Re: The Thomas Cowley School – Window proposal

Further to your recent communication please find points that need to be considered for the replacement windows to the Old School Building

01	Window Type 01
PP400	1:20

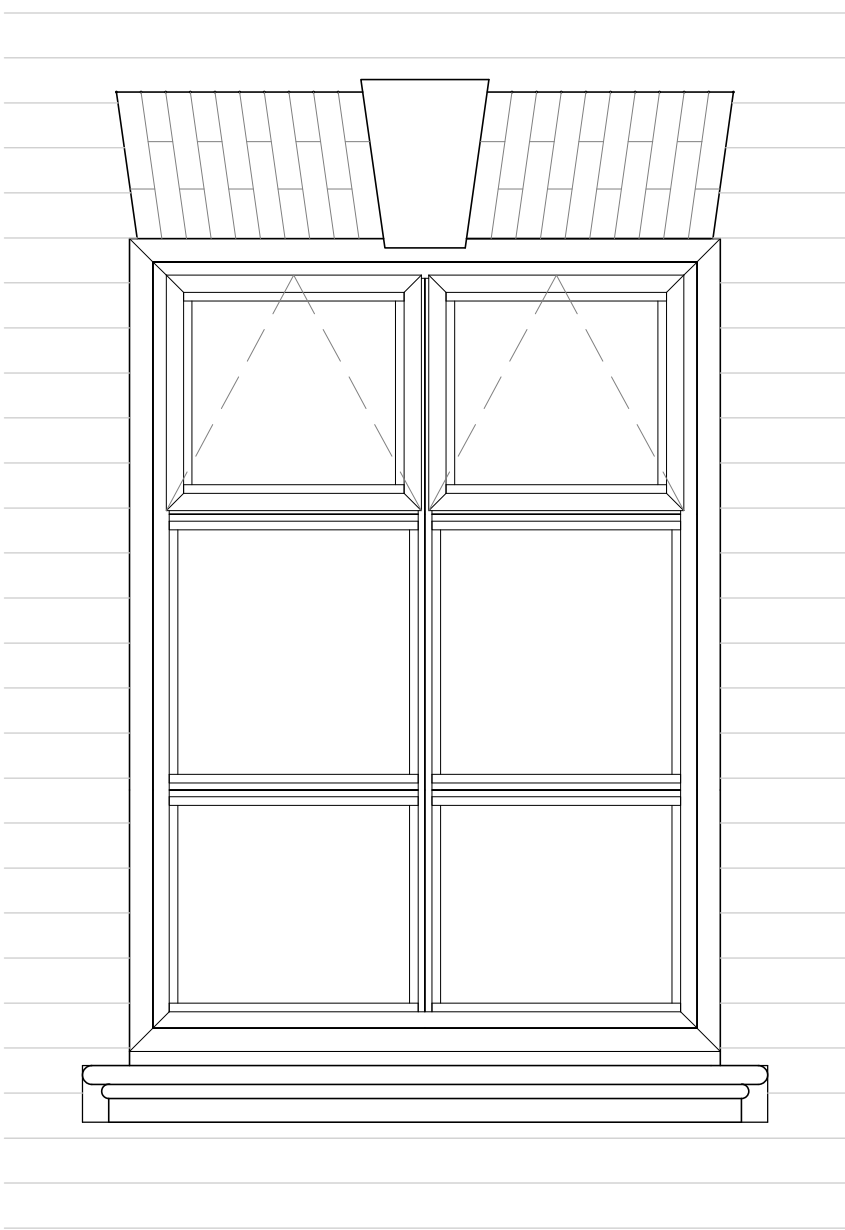
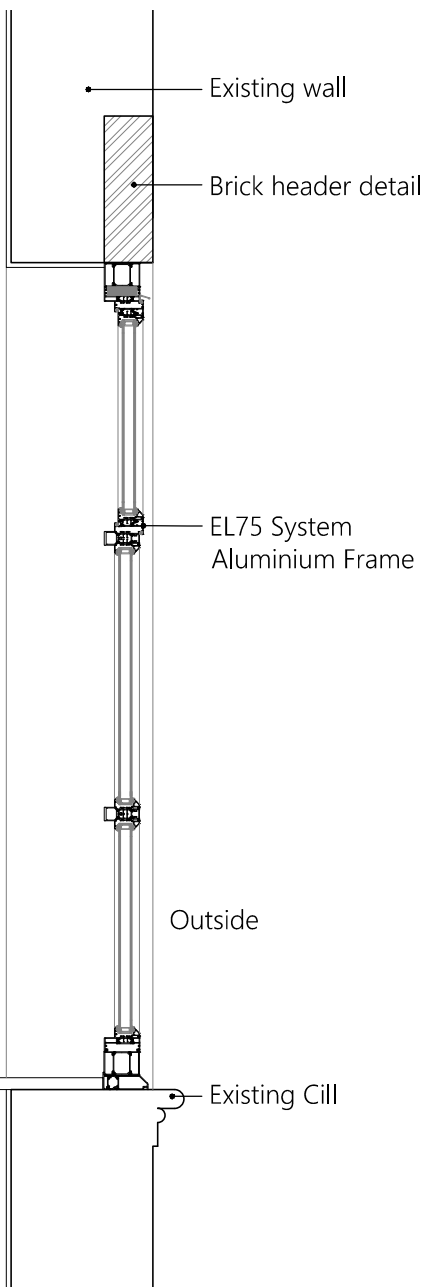
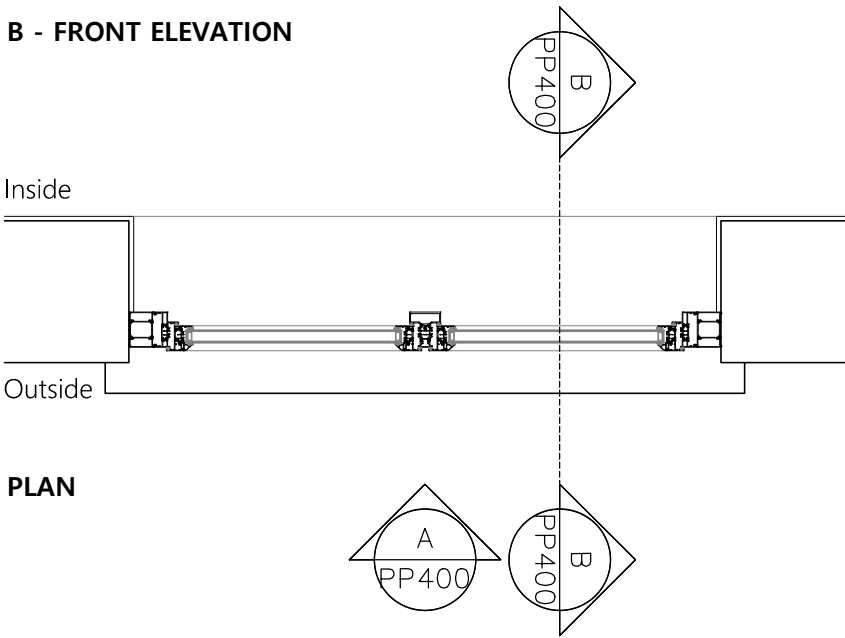
1. The internal structural sizes, especially in width are circa 100mm smaller than the external structural size. Therefore, there is a requirement to include for 'add ons' down the jambs and to the head of the window frame to make up this difference. This lends itself to a 75mm outerframe and add on to ensure the glass

4. As these windows are circa 2100mm high they are designed with a specific mullion (vertical member) to satisfy the required wind loading of this building in this location. This has been approved by our Technical team

01	Window Type 03
PP400	1:20

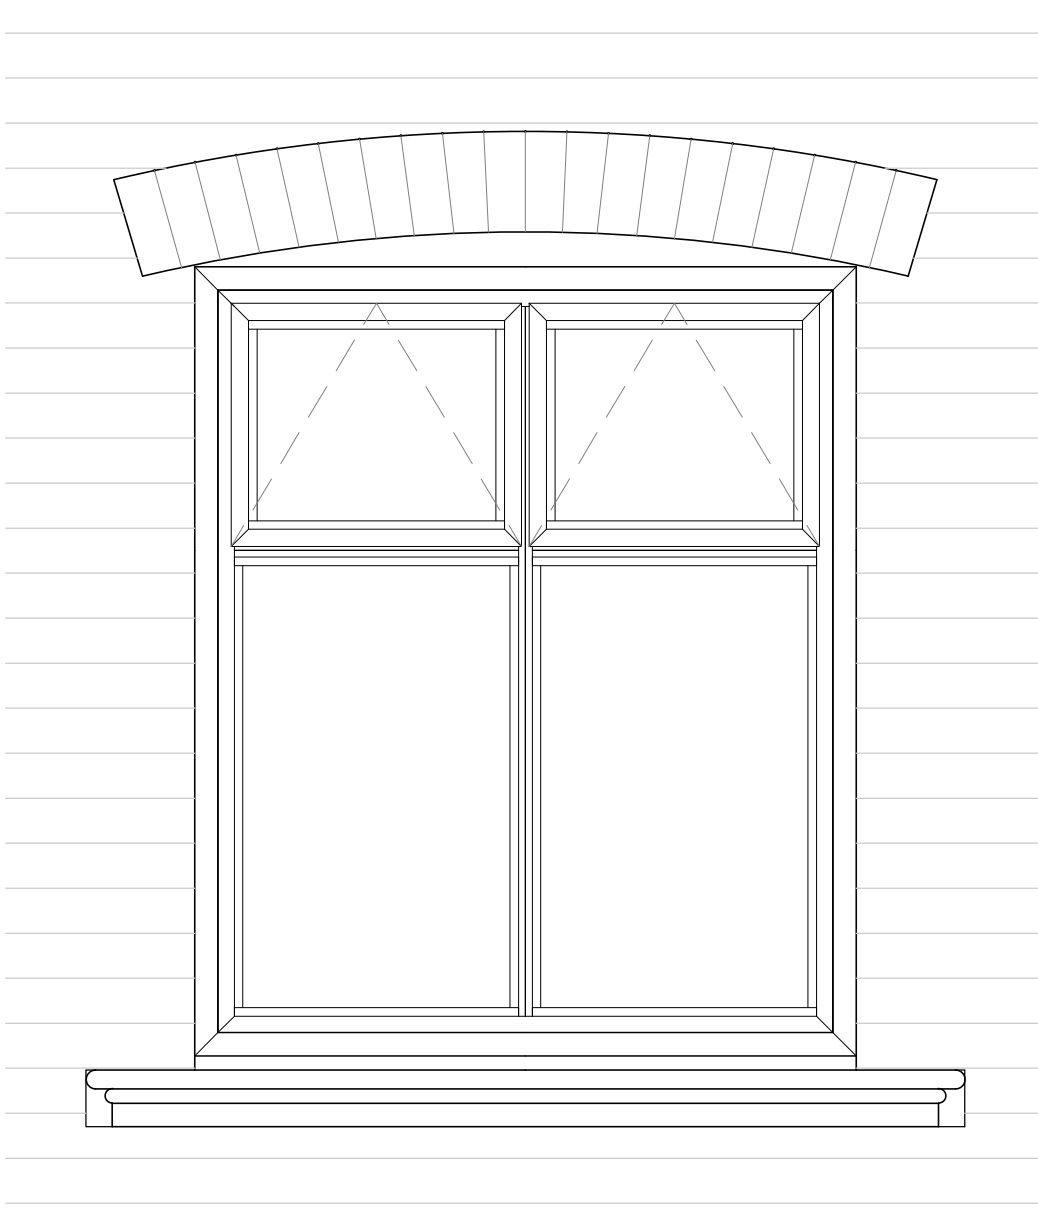
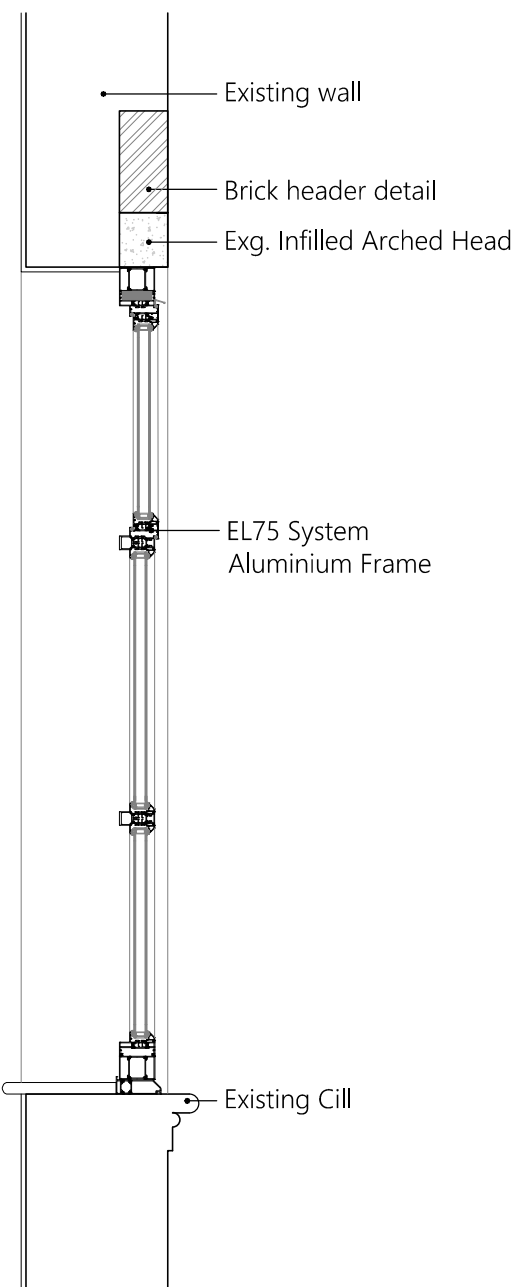
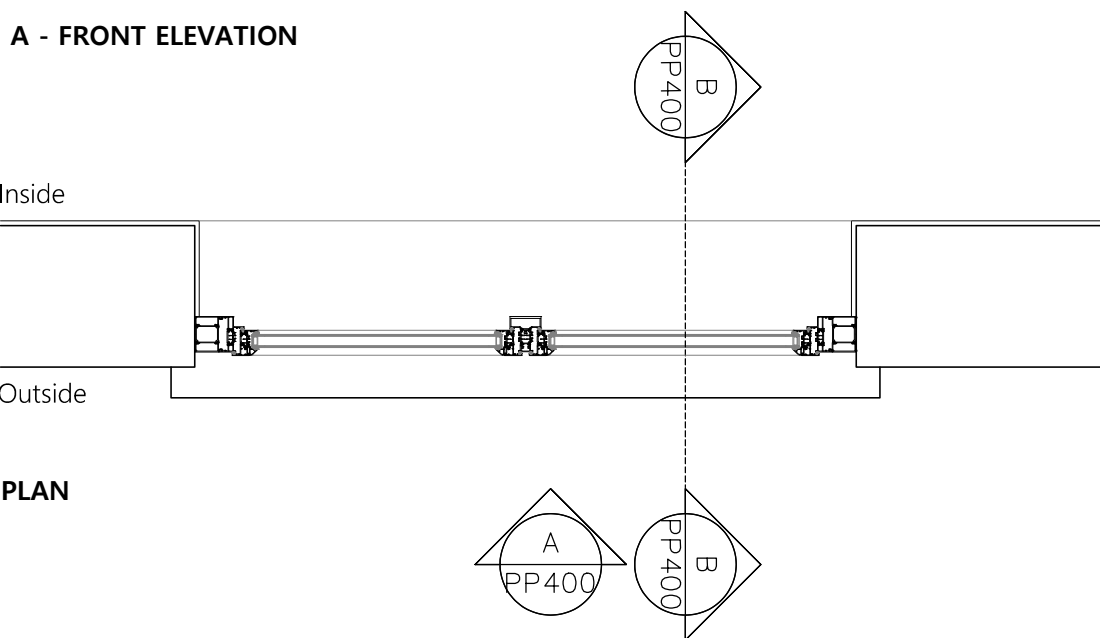
5. To reduce glare of the glass we could propose the glass to have a grey anti-sun tint
6. As the opening casements are at high level, for CDM regulations these will need to be operated by winding teleflex gearing. It is not possible to fit this type of mechanism to slim aluminium systems. There isn't enough room or strength to casement or transom so the gearing will not be fitted adequately. This would not be fit for purpose
